August 10, 2021

Harnett County Government Complex
307 W. Cornelius Harnett Boulevard
Lillington, NC 27546

Re: Status of Improvement Permit Application: BRES2107-0055 and BRES2107-0056

PROPOSED SURVEY FOR:

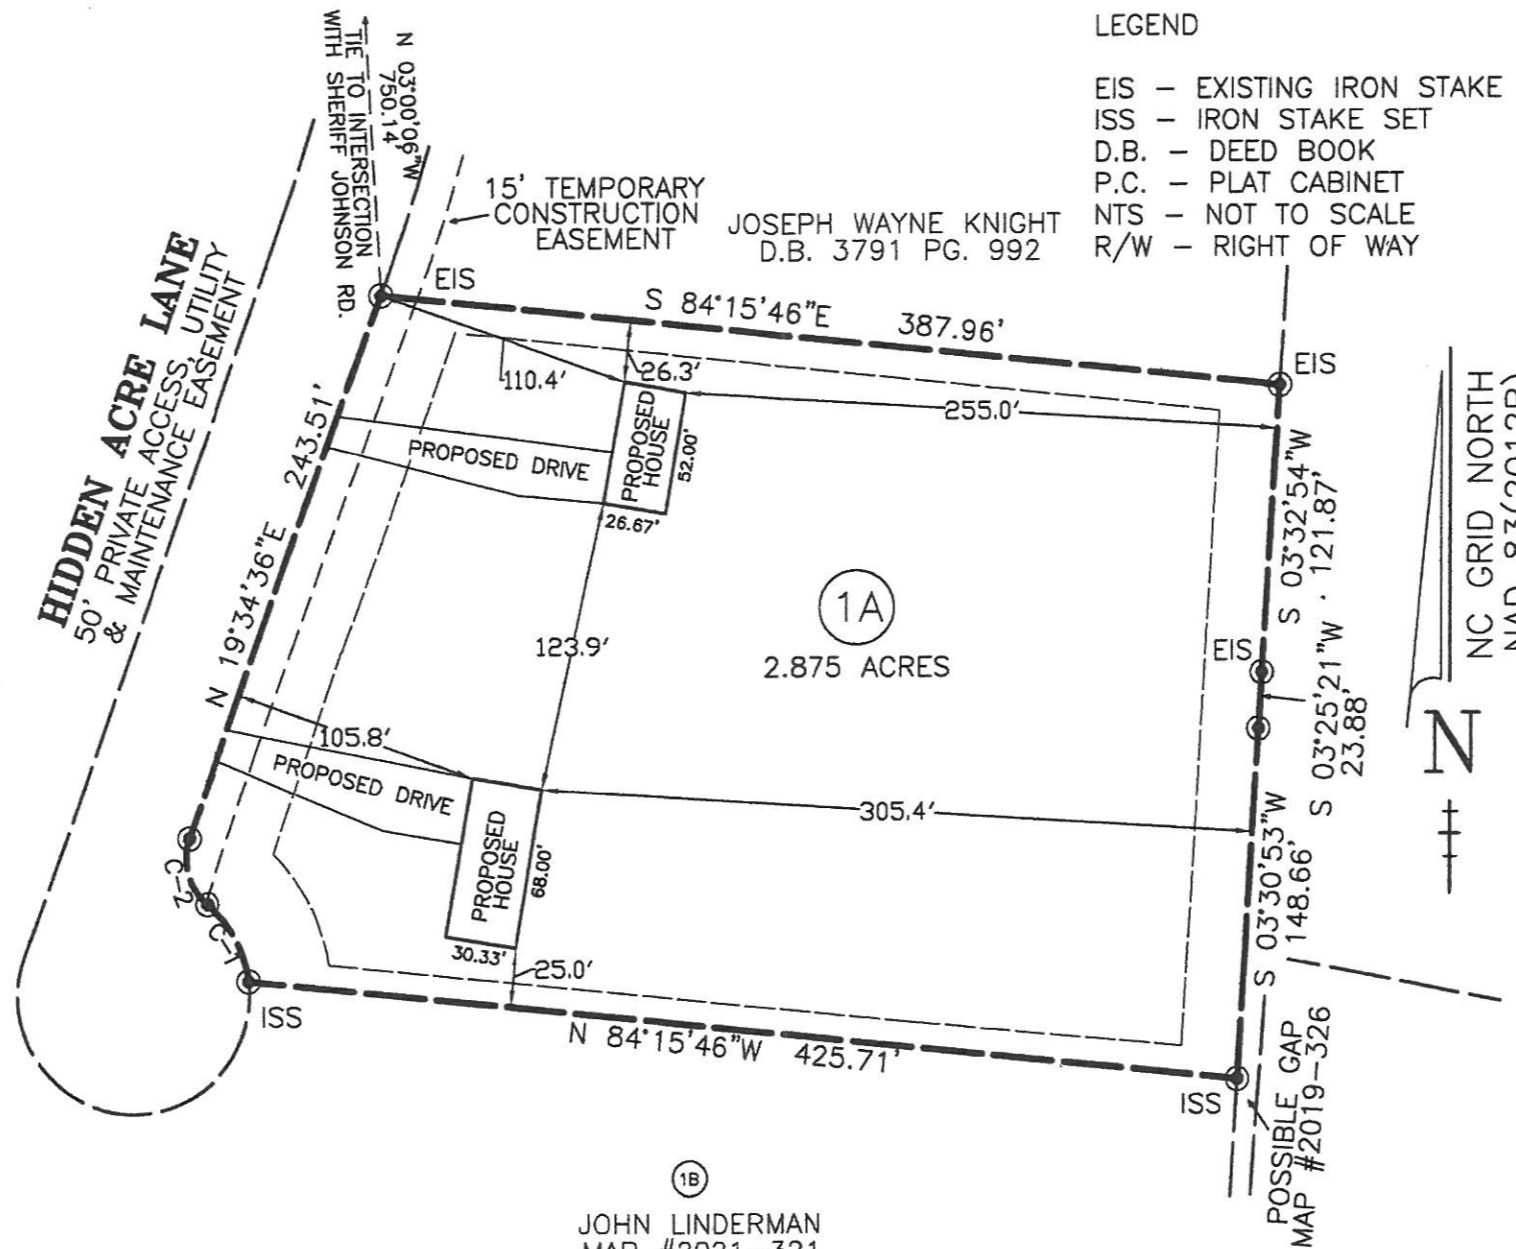
- 7. **Other- Planning and site plan issues. (1) No listed front setbacks on site plan. (2) Site plan does not match deed. Appears applicant has an unrecorded map/deed showing division of property that is not listed on GIS. Site plan shall be revised or deed recorded. (3) Property lines were not marked. (4) Rear irons were not located. Additionally, all front irons on map were not available and unknown iron and stake located at front between two homes. (5) No decks, porches, barns, or pools on site plan. Provide on site plan if anticipated being included.**
